Subject: Re: FW: 2020/90441 - Pennine Service Station, Bradley Road, Bradley, Huddersfield HD2 1QD

Thanks for the email, I have been consulting with our drainage engineer who has commented as follows:

DRAWING TITLE
Drainage Layout

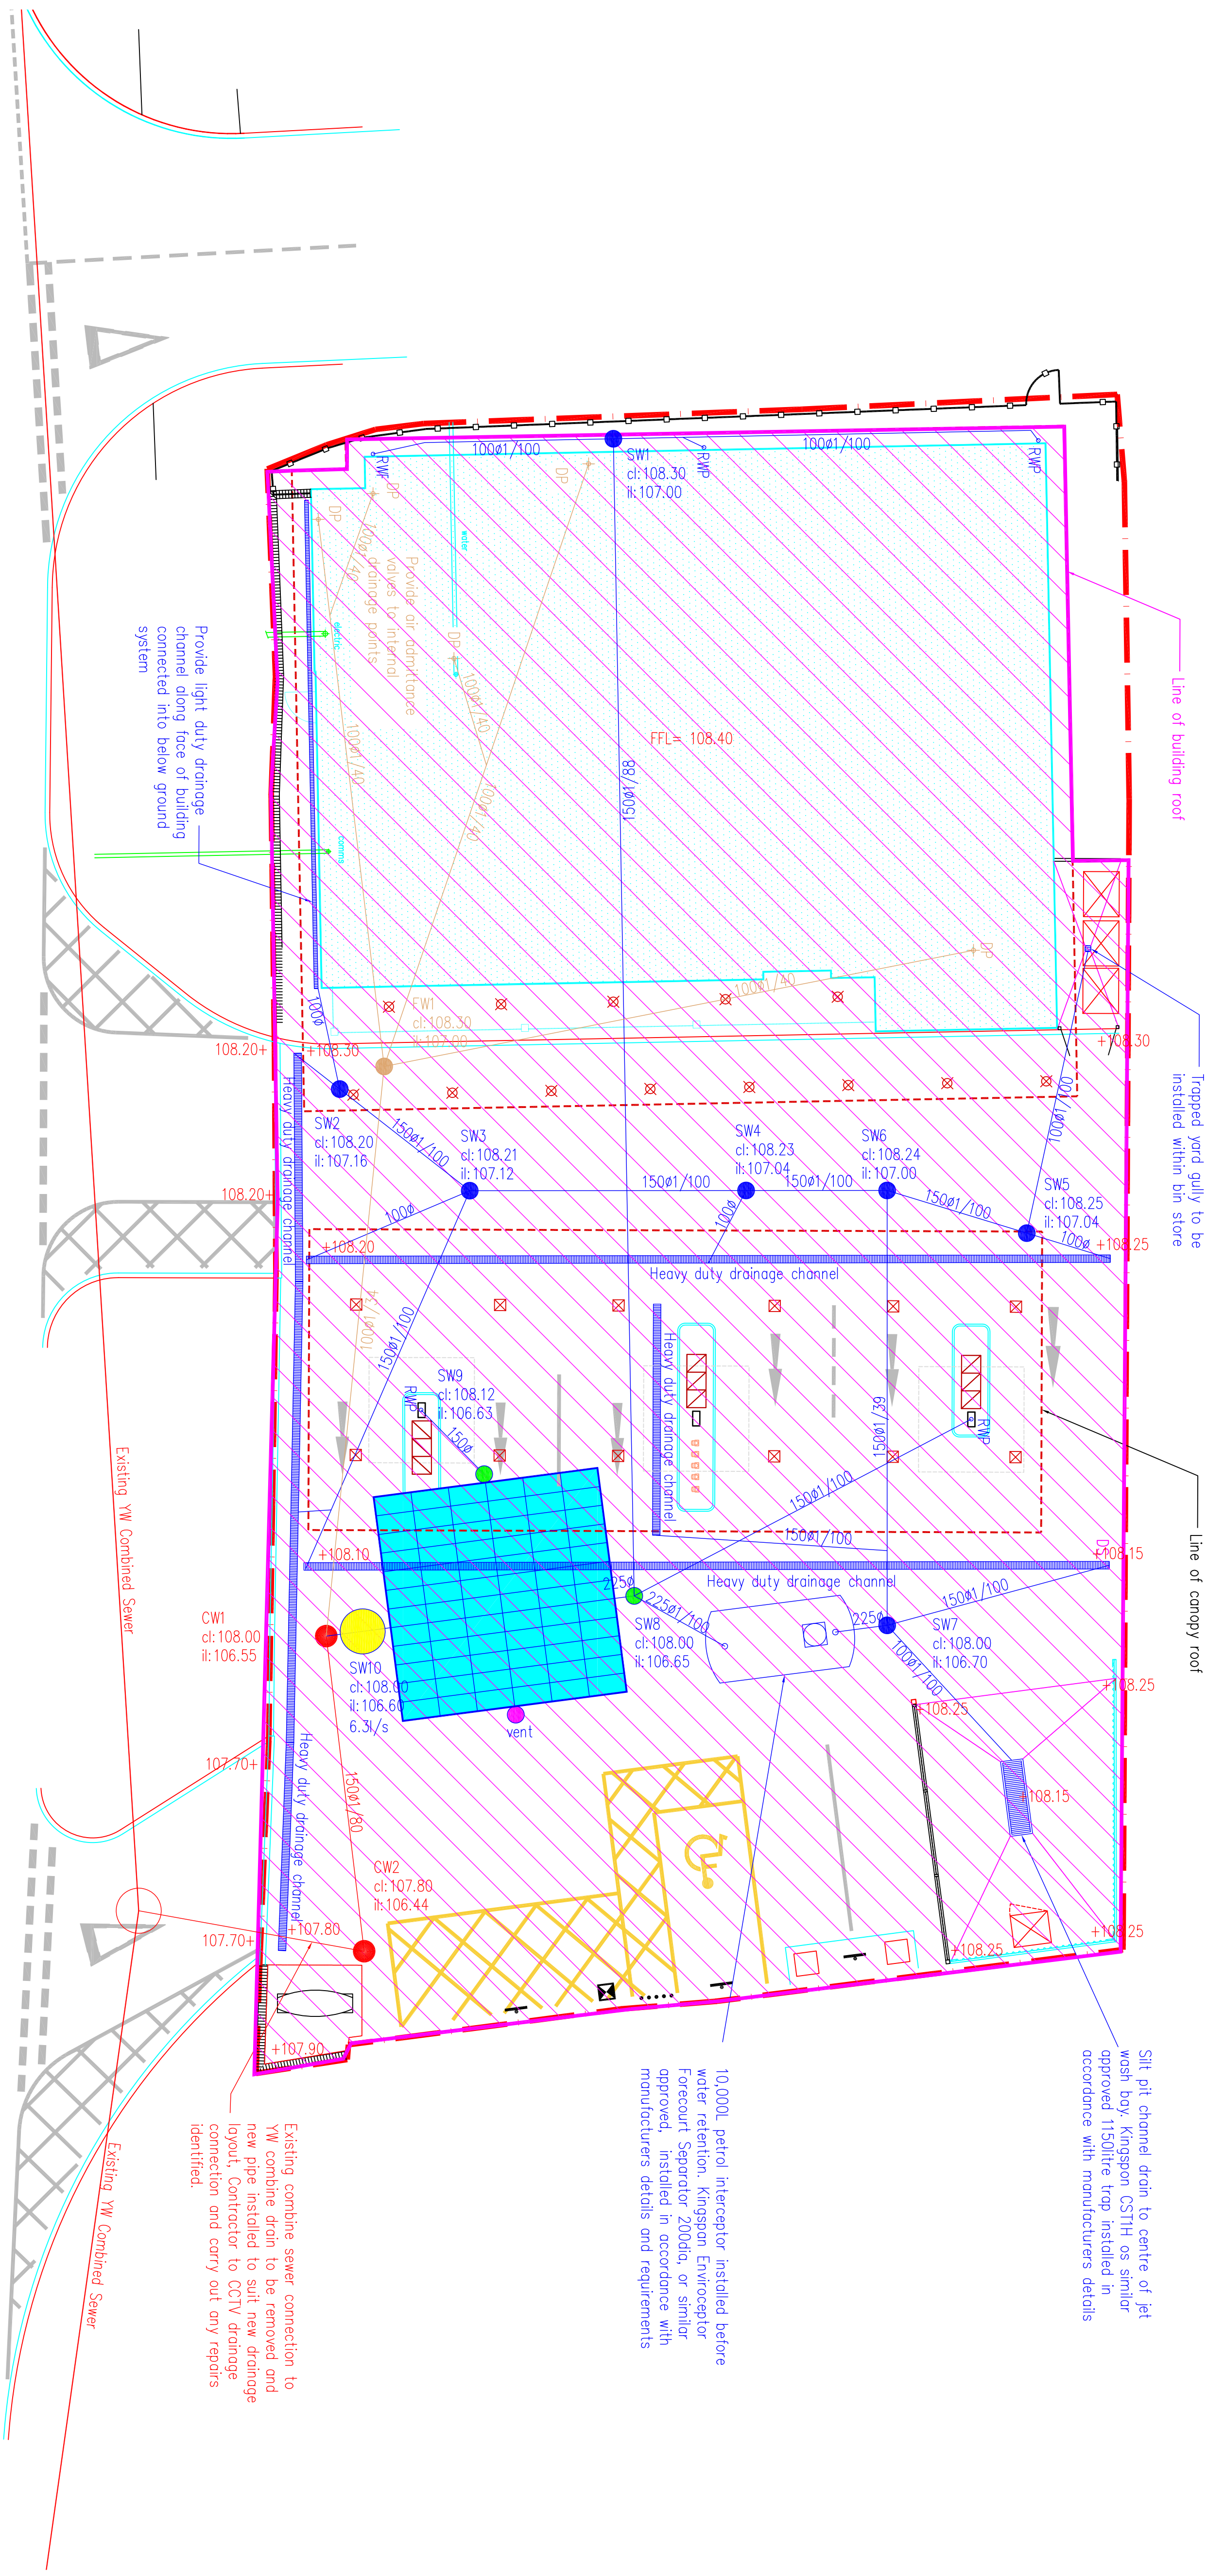
I am using industry standard software (WINDES) and inputting the tank size shown on the drawing i.e tank size of 36m² by 0.8m deep with a void factor of 95% as shown on page 5 of the Micro Drainage calculation included on the report. The model summary on pages 1 and 2 of the Micro Drainage calculation says the system is OK therefore there is no surcharging or flooding on the site.

The total volume of 29.9m³ occurs over a 30 minute winter storm. However, the peak volume required at any moment during the 30 minute storm is less than the 28.8m³ of storage available within the tank and an experienced drainage engineer would be familiar with this.

The LLFA have previously requested the applicant provide details of the 'light duty' and 'heavy duty' channels proposed to be used on site. Some details of the heavy duty channel have been provided within the Drainage Details drawing, however, no lengths or details on the light duty channel have been shown.

The LLFA have previously noted that water from the jet wash should not be connected to the surface water system. Water from cleaning areas will be silt laden and also contain cleaning contamination, this could result in siltation or contamination of water. The connection has now been changed and the jet wash water is proposed to be discharged as foul. The LLFA highlight that the applicant should consult with Yorkshire Water as the jet wash may require a flow control or an attenuation feature for balancing.

Notwithstanding standing the above I have requested that the tank is increased to 7m x 6m as is indicated on the attached revised drawings, which will now provide 42sqm by 0.8m deep, providing a volume of 31.93 cum including the 95% void factor. This is now larger than the maximum volume as indicated on the calculations as included in the report in your possession and I hope that this is now acceptable to LLFA.

Details of both light and heavy duty drainage channels have been provided on the drainage details drawing as previously issued. The drainage layout indicates locations of both light and heavy duty drainage channels and there is only one section of light duty drainage channel located on the footpath against the building parallel to Bradley Road, all other drainage channels on the site will be heavy duty. This was indicated clearly on the original drainage plan and not sure what bearing this has on the LLFA concerns, but trust this is now resolved.

It is clearly shown on the drainage layout that a silt trap, type Kingspan CST1H will be installed to the jetwash area. Attached is a detail of the specified type and I note that these have been used on many sites for the jet wash areas. As noted on the comment above the jetwash now discharges to foul water drainage and consultation with Yorkshire Water has been made as indicated on the copy of email to YW was included in the previous response. Obviously the consultation is still ongoing as YW are not working at full capacity at the moment, due to the current situation, but trust this deal with LLFA recommendations.
